**Boggabri Coal Mine - Project Approval Modification  
Environmental Assessment (MOD 5)**

**Response to Submissions Report**

2 May 2016

Client: Idemitsu Australia Resources  
Title: Boggabri Coal Mine - Project Approval Modification Environmental Assessment (MOD 5)  
Subtitle: Response to Submissions Report  
Document No: 2200545A-ENV-REP-005 RevI  
Date: 2 May 2016

Figure 6.2
Registered landholder works in borefield region

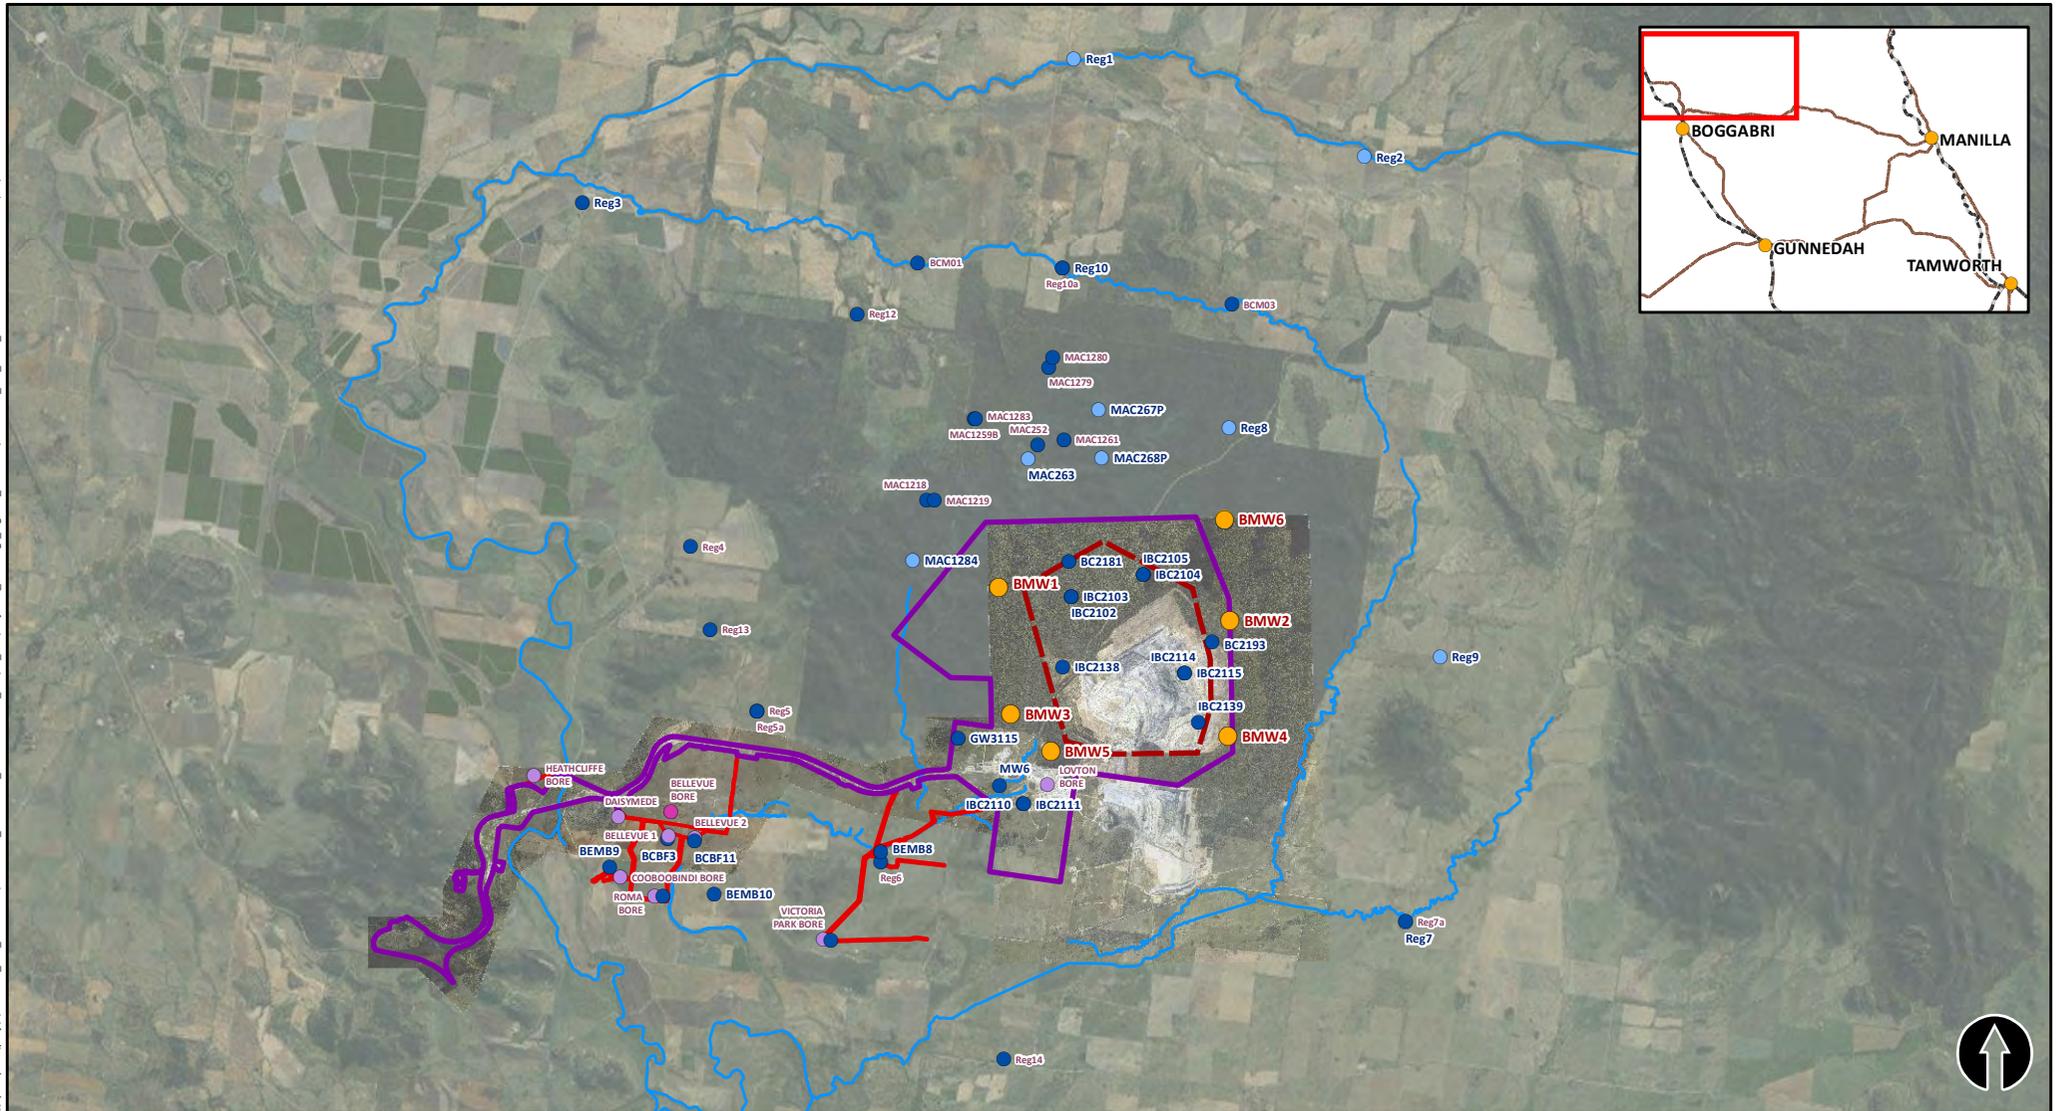
However, Figure 6.2 in the EA identifies the Heathcliffe bore is located in Zone 5, whilst all the other bores are in Zone 4. There is no record currently of Boggabri Coal holding a WAL in Zone 5, therefore they would be required to obtain the appropriate entitlement.
